Case Officer: Andrew Lewis

Applicant: Heyford Park Commercial Developments Limited

Proposal: Partial discharge of condition 10 (Landscaping Scheme) 14 (Tree Pits) of 16/01000/F – Phase 1 only

Drawing No: 1619 A7 03 L

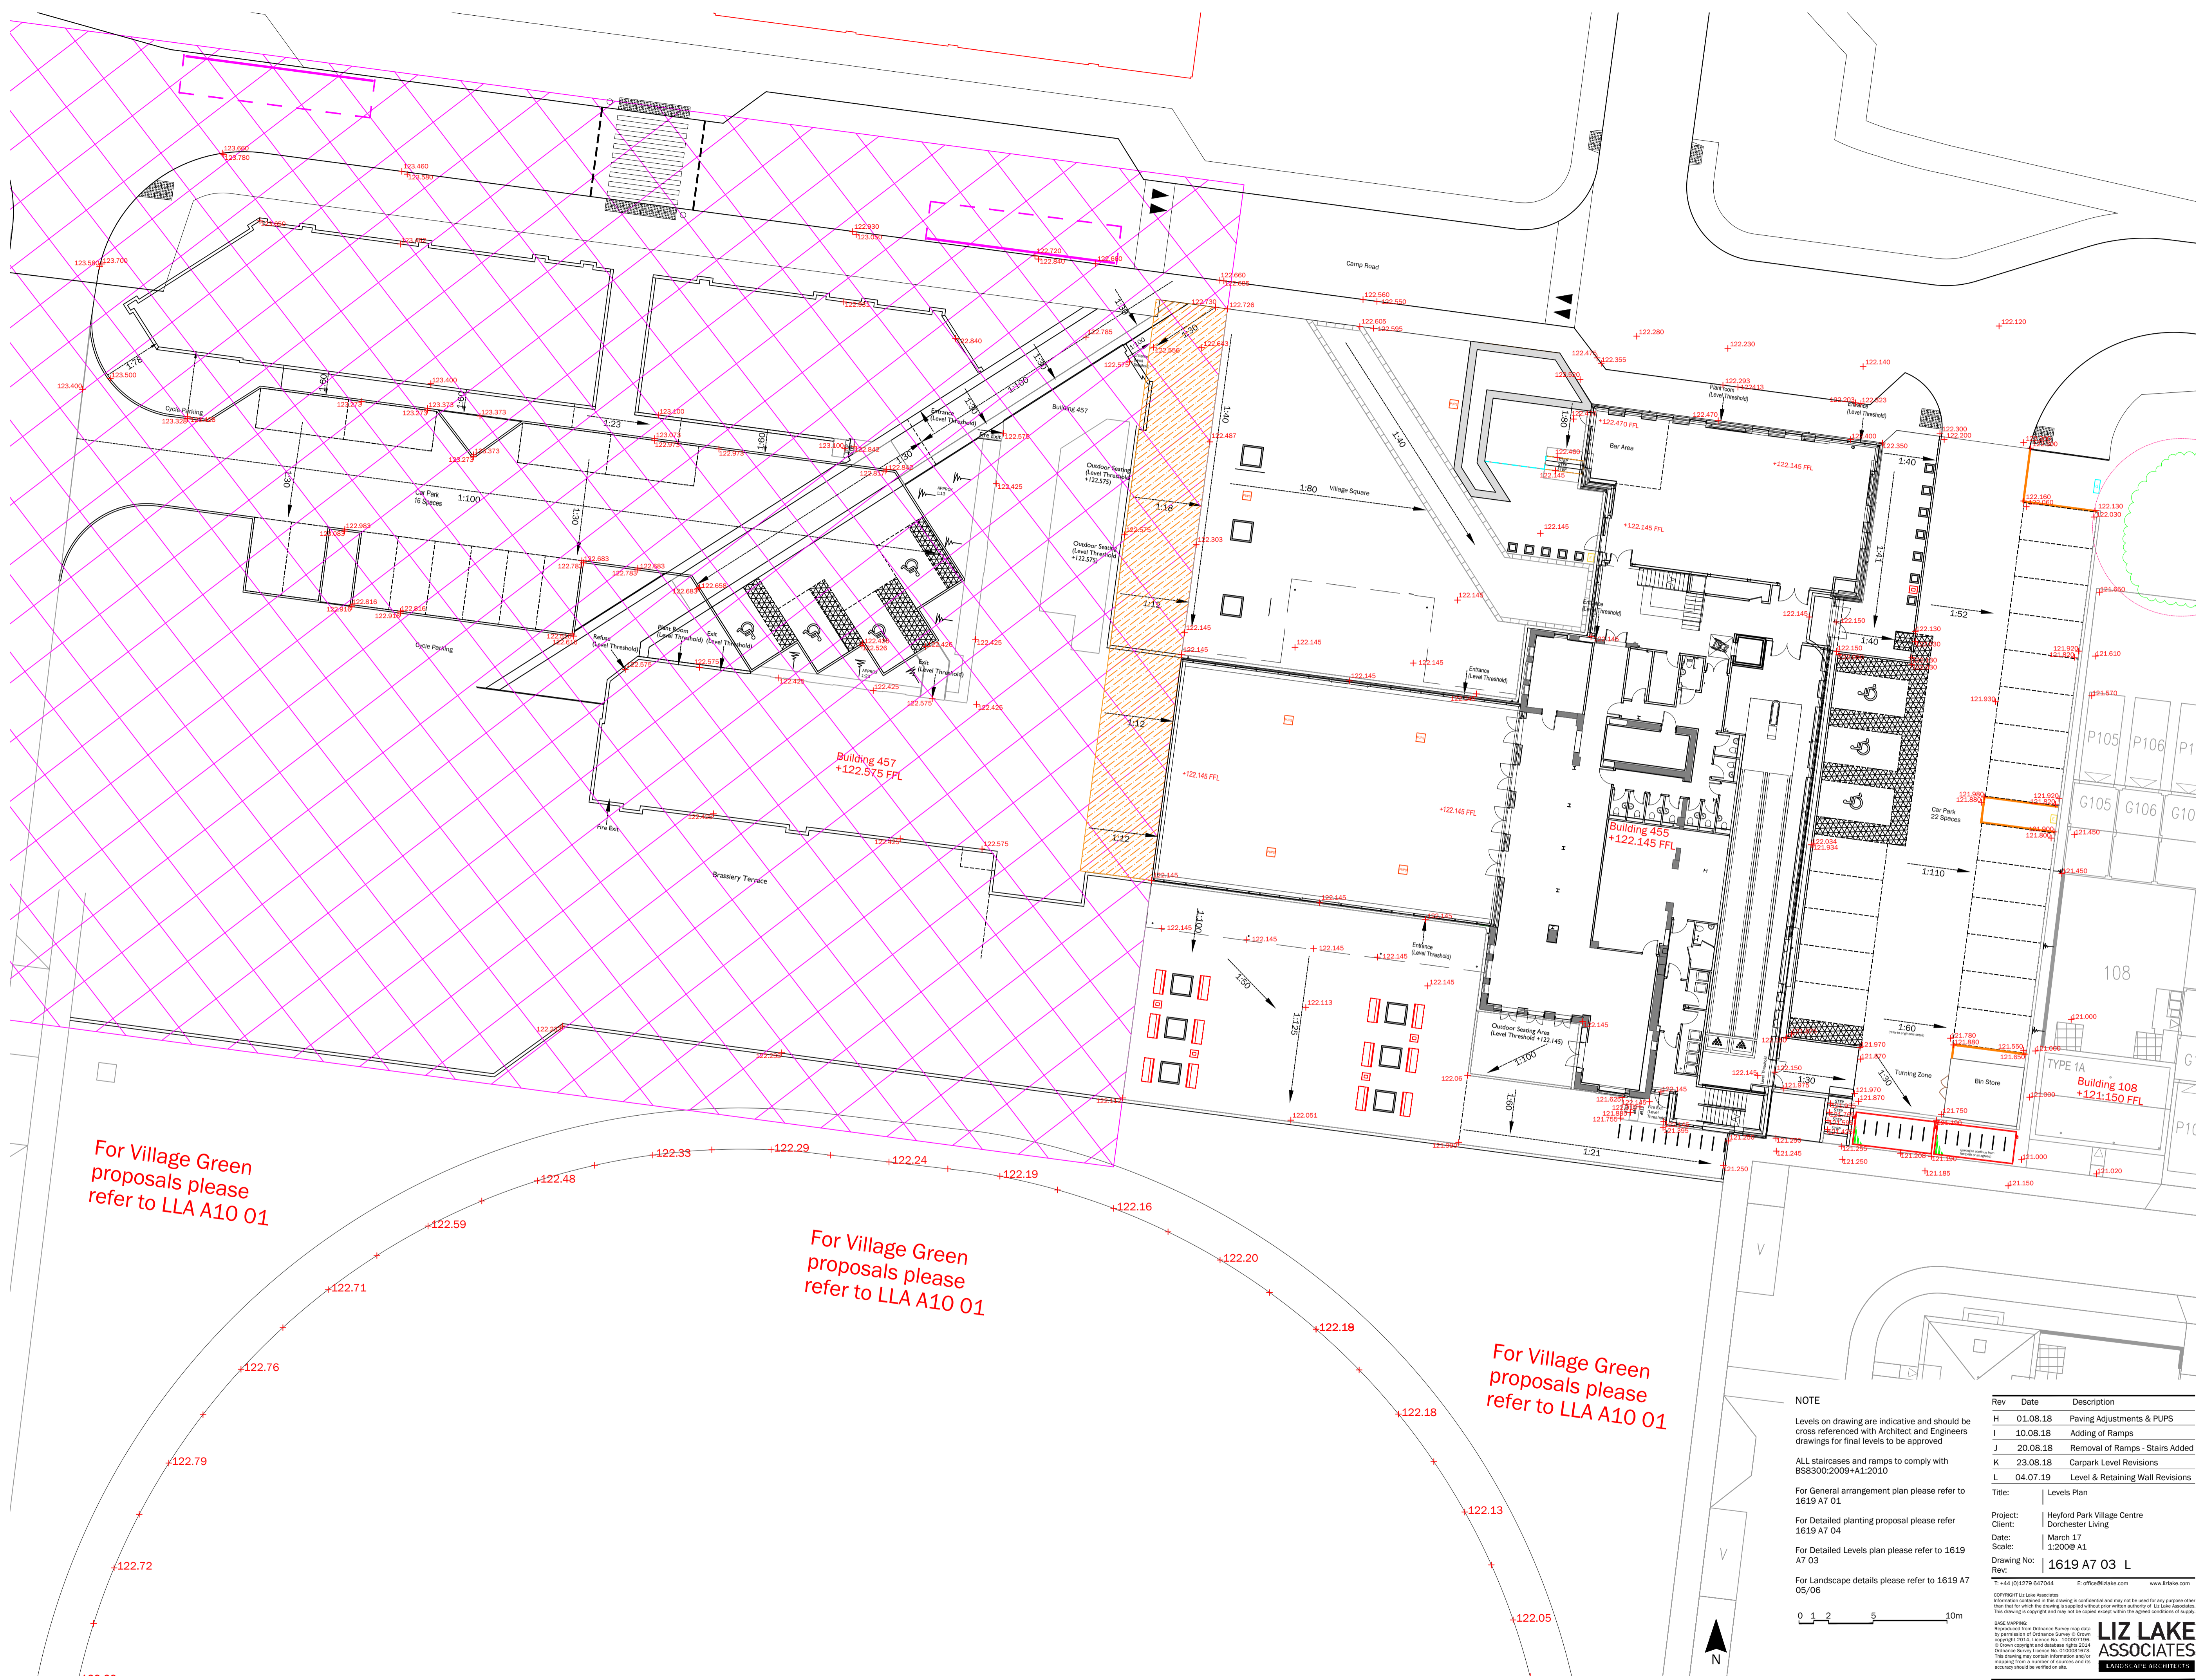
- 4.1 The Council's Arboriculturalist was content with the tree planting pits.
- 4.2 The Council's Landscape Officer considered 19/00100/DISC and 19/00111/DISC together and expressed concern initially over the drainage plan and requested a single feature tree replace three Persian Ironwoods. Following receipt of amended plans his concerns have been addressed.

- 5.2. To overcome the concerns of the landscape officer, plans were revised to show an extended retaining wall and slight change in levels. The three Persian Ironwood trees are retained in the proposals. A single large tree was considered but is not possible here as it would need to be planted into the ground affecting the drainage system (as opposed to the trees as shown which are placed in planters, not affecting the drainage system).

Approval is given for the landscaping scheme, landscape management plan and details of all purpose built tree pits as shown on the following revised drawings:
